KITITITAS COUNTY COMMUNITY DEVELOPMENT SERVICES

August 9, 2018

RE: SX-18-00019 Romans Shoreline Exemption – Request for additional information

SITE PLAN

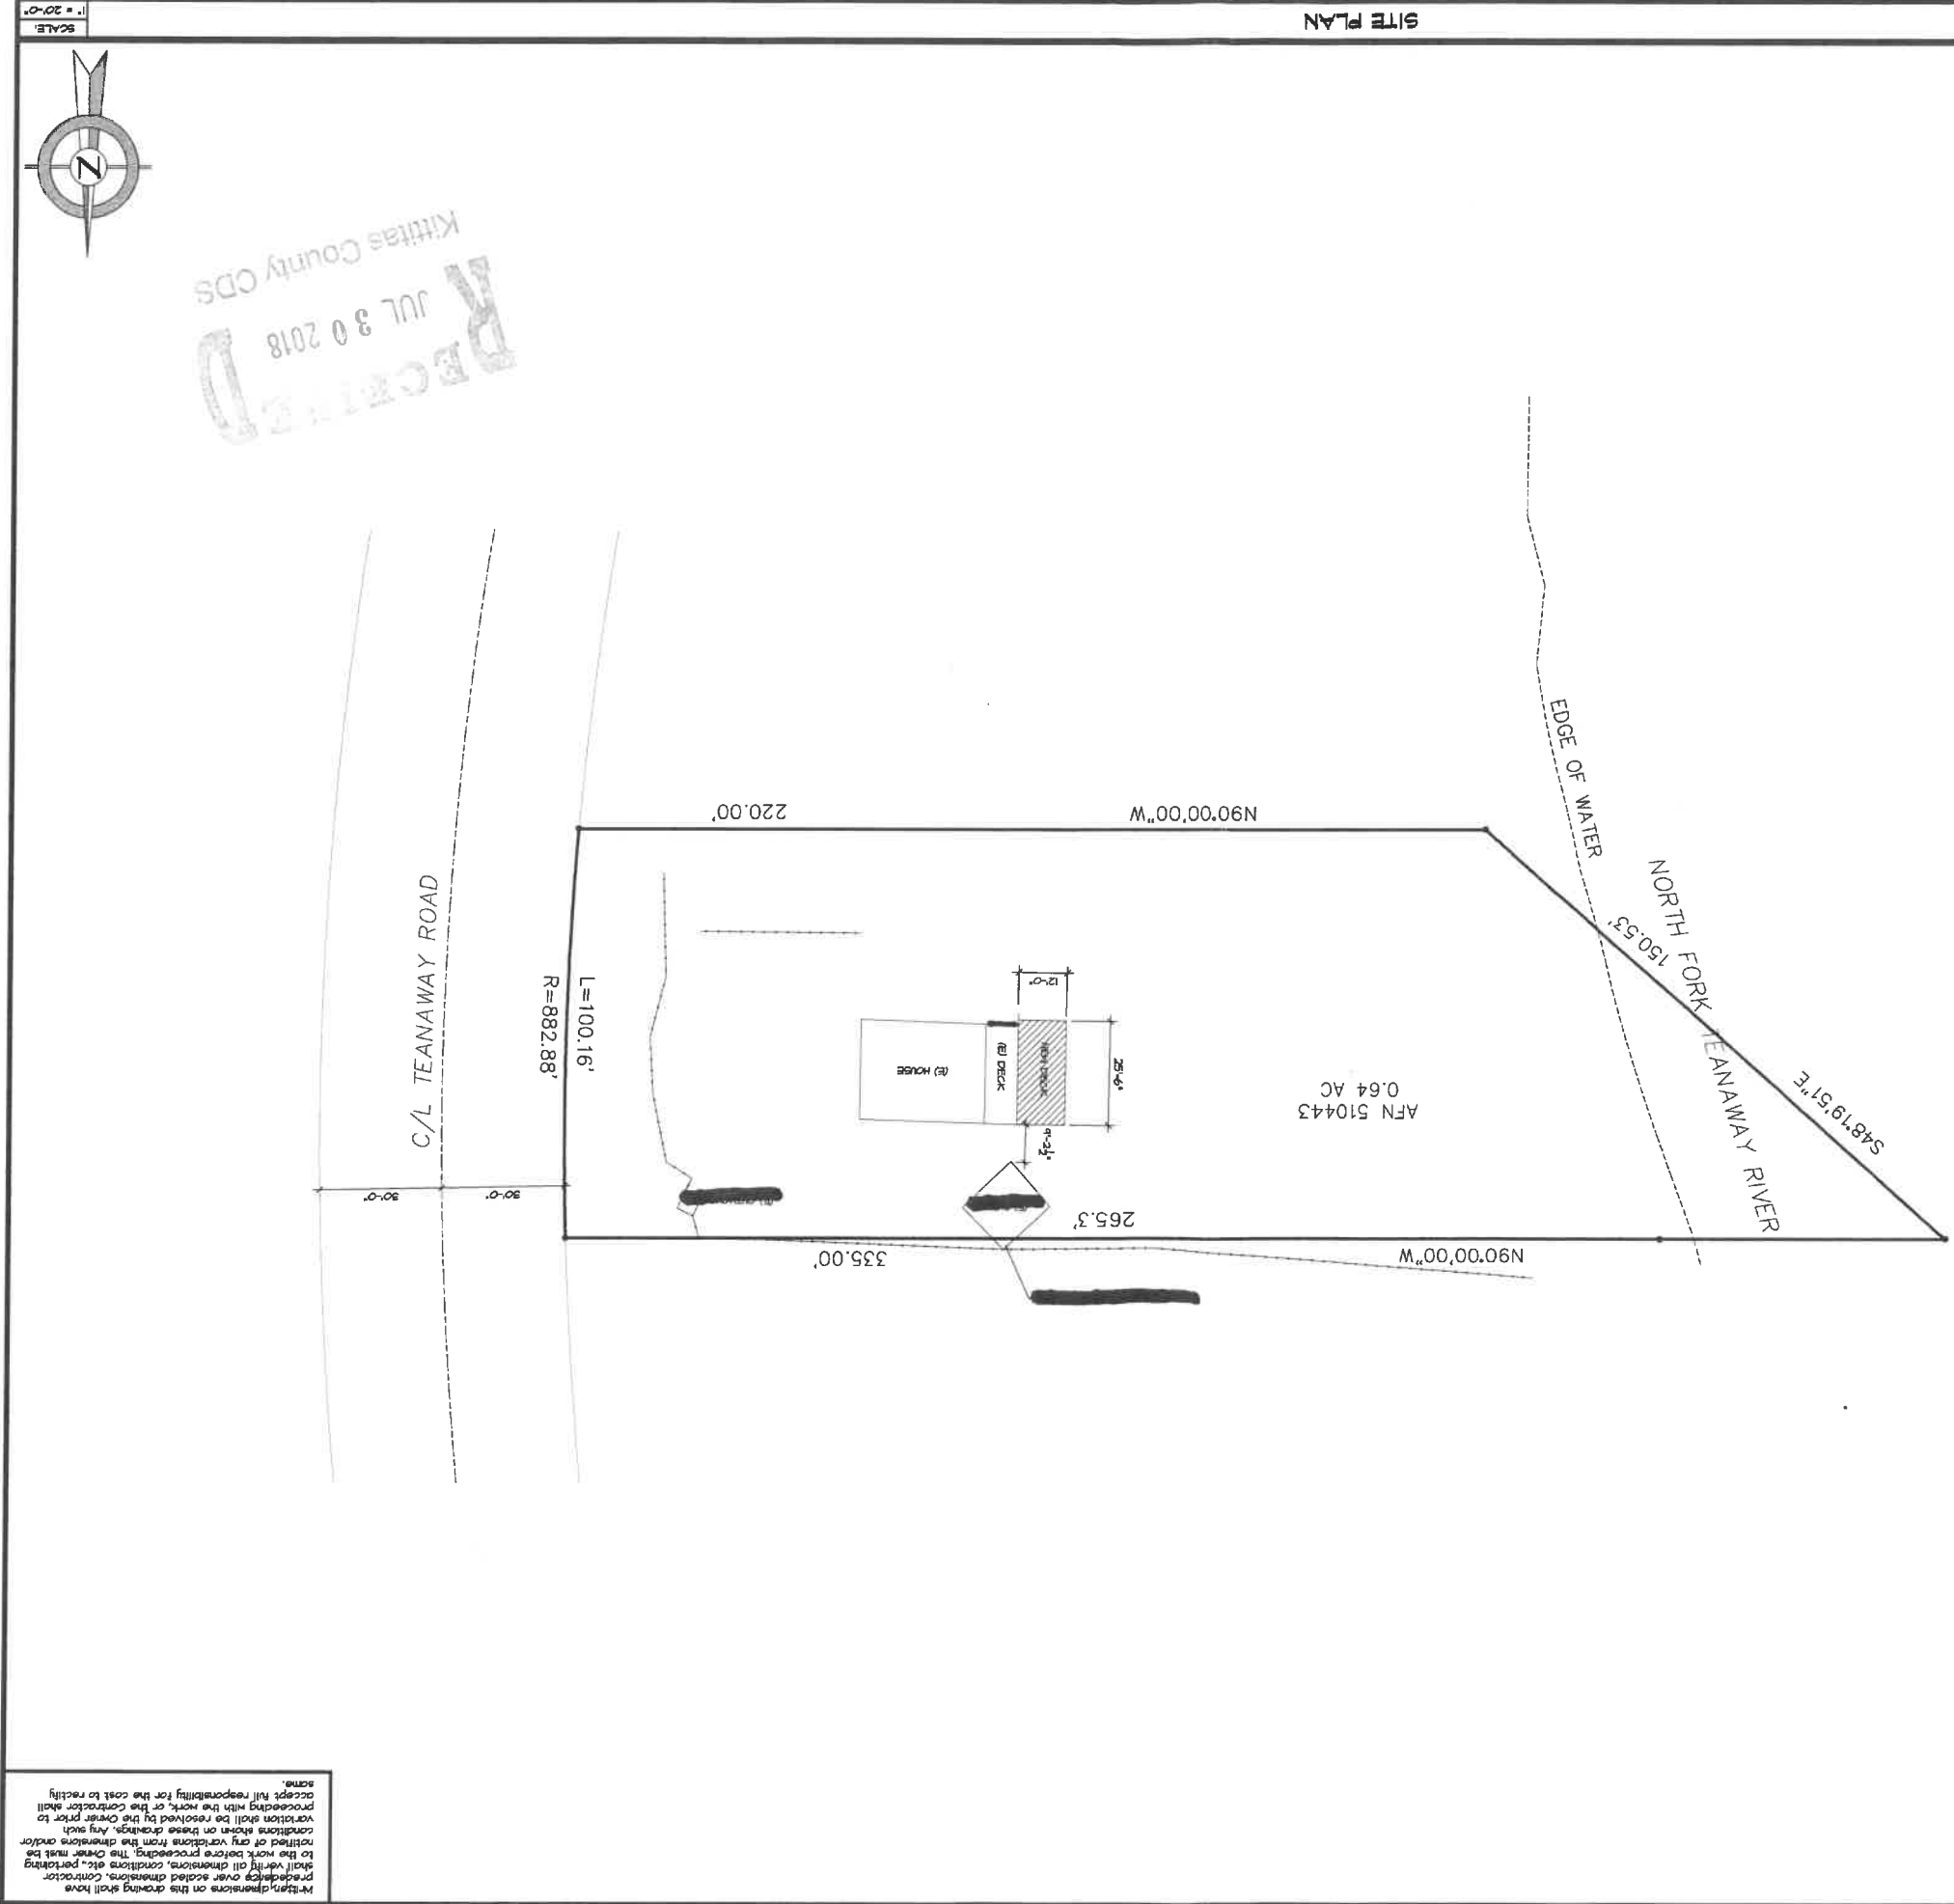
- 1) Access to the property must be noted on the site plan.
- 2) All legal setbacks must be indicated on the site plan.
- 3) Any well or septic systems (and related drainfields) must be represented on the site plan.
- 4) The site plan indicates the project is 130' from the "edge of water." Shoreline exemption review requires a precise distance from the Ordinary High Water Mark (OHWM). Please indicate this distance on the site plan.

Please submit an amended site plan demonstrating the items listed above. CDS will review and process your application once this is clarified.
